Our ref: SSD-37558583

8 July 2022

Subject: Additional Matters for Submissions Report - Lot 1 Bringelly Road Business Hub - Warehouse Facility (SSD-37558583)

Attachment 1 – The Department’s Comments

200 AND 300 SERIES BLOCK WALL

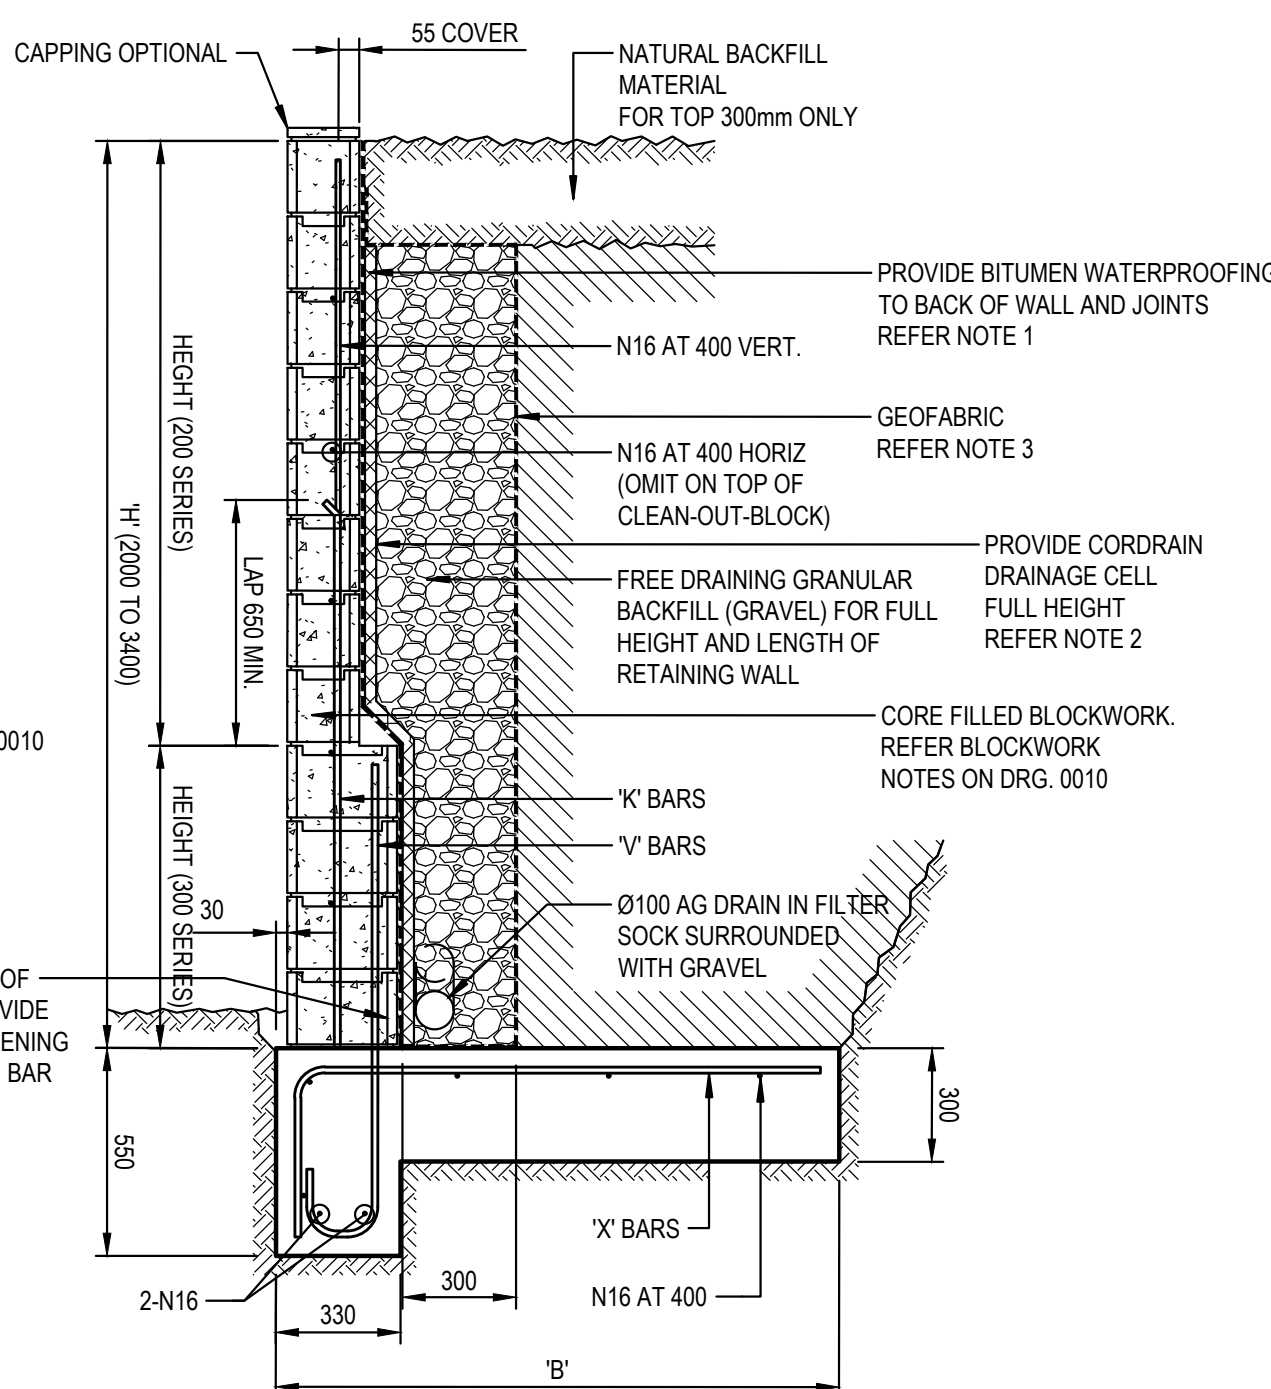
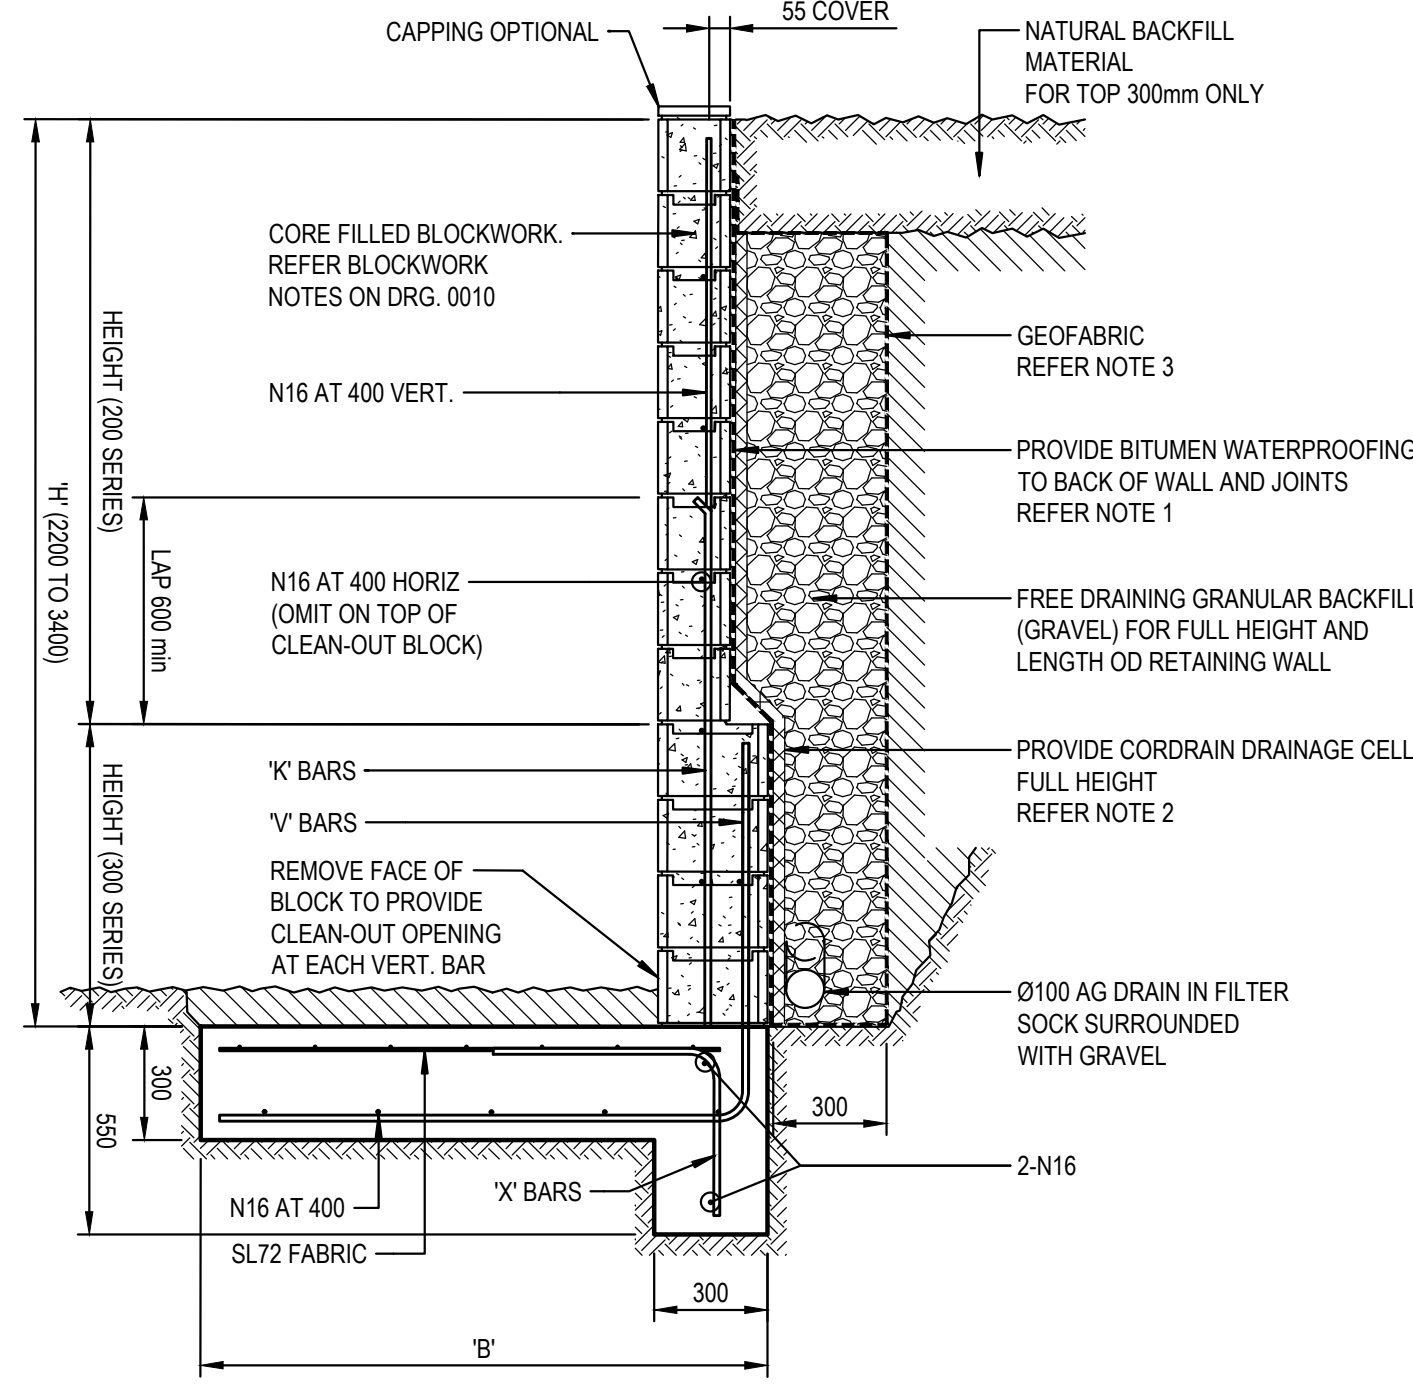
4. It is acknowledged that significant retaining walls are proposed as part of the development. The engineering plans showing these may reach more than 3 m in height. The Department is concerned that retaining walls of this height may cause visual impacts. Further details are required to determine how these walls will impact on the visual amenity of the site, including the inclusion of these walls on elevation plans, multiple section plans and montages to demonstrate the visual impact of these retaining walls from within the subject site and from neighbouring sites.
